Recommendation Report for Listed Building Consent for Alterations, Extension or Demolition

REF NO: A/3/14/L

LOCATION: Angmering Manor
High Street
Angmering

PROPOSAL: Application for Listed Building Consent for the construction of building comprising of 5 no additional hotel bedrooms (resubmission following A/100/13/L).

PROPOSED CAR PARK LAYOUT

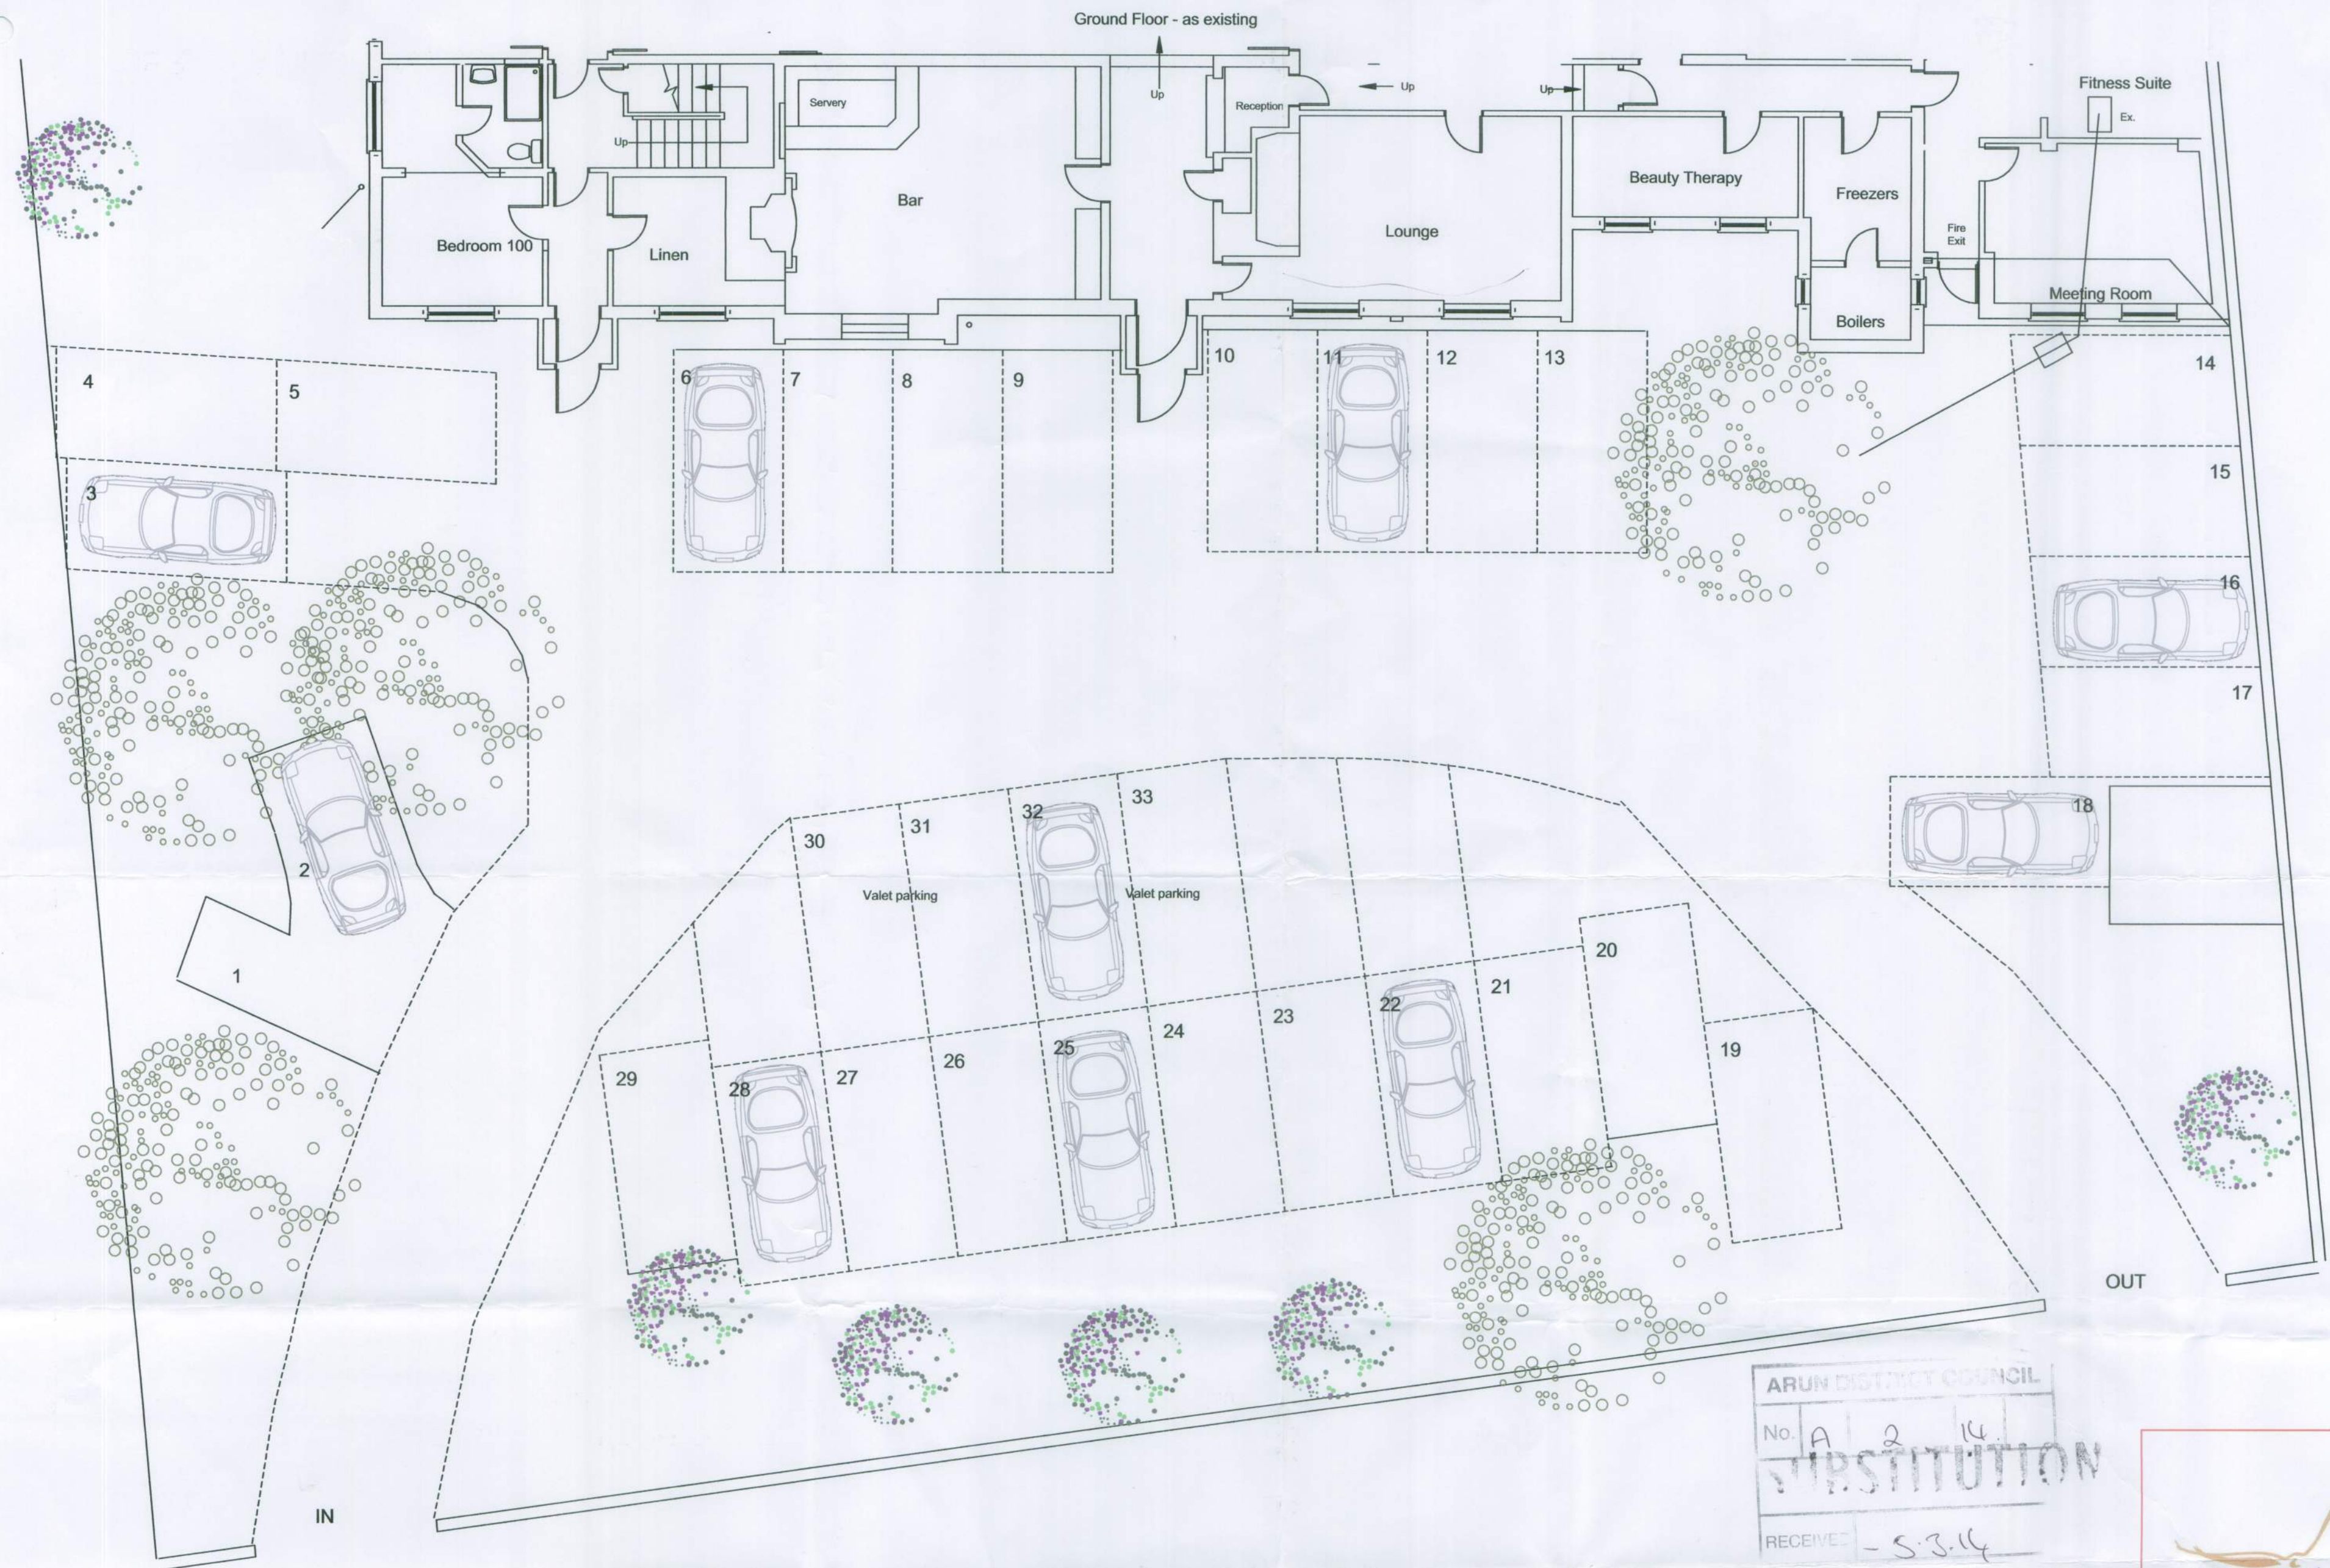
Objection - Further work is required regarding car parking. A swept path analysis should be submitted. The materials proposed for the cladding do not appear to be in keeping with the Conservation Area.

The car parking and swept path analysis have been submitted from the agent in accordance with County Highways comments on the planning application. Re-consultation of the planning application has been undertaken, but these changes are not material to consideration of this application for Listed Building Consent. The Historic Building Adviser and Conservation Officer have no objection to the cladding which would match the existing rear elevation of the restaurant.

Title
ADDITIONAL GARDEN BEDROOMS
ELEVATIONS

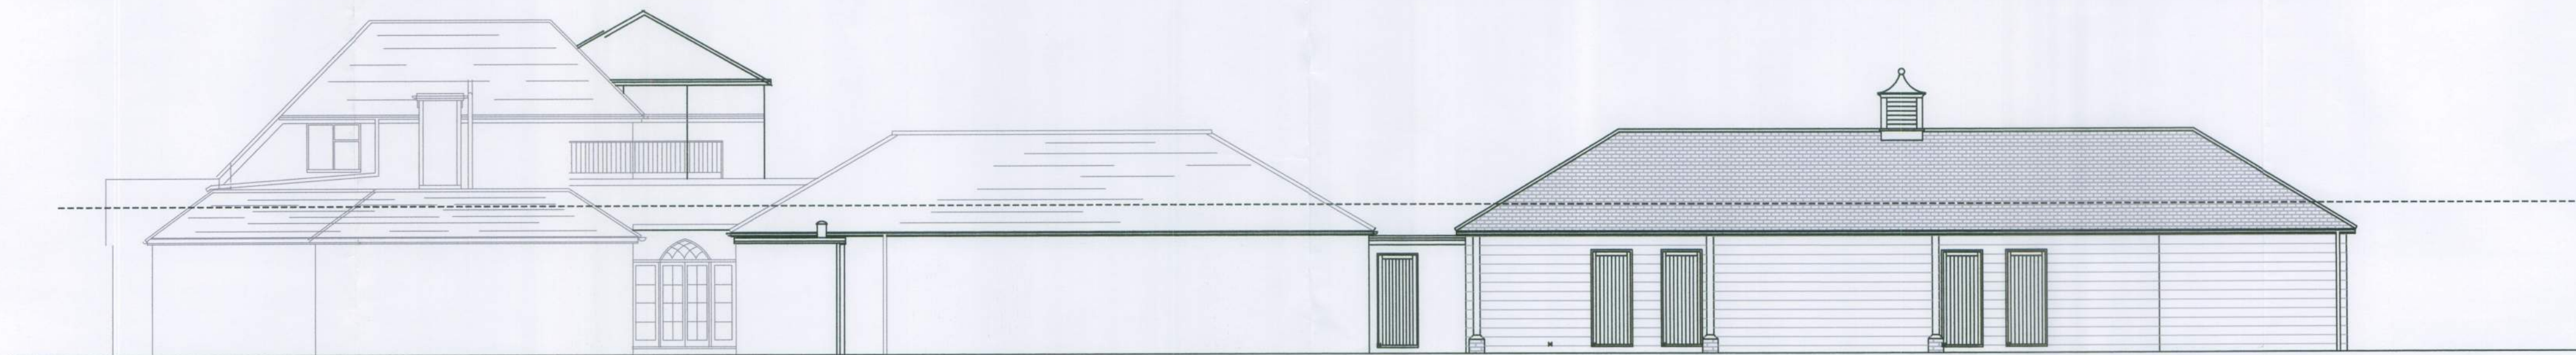
Whilst the location and scale of the building is generally acceptable, there remain reservations with its design. Of particular concern is the use of Georgian, arch windows which appear at odds with the half hip roof and are not particularly convincing on an outbuilding. Recommend that the 'arched' element is removed.

A further improvement could be the use of a full hip roof with deeper eaves to create a more simple and elegant roof form, particularly given the depth of the building.
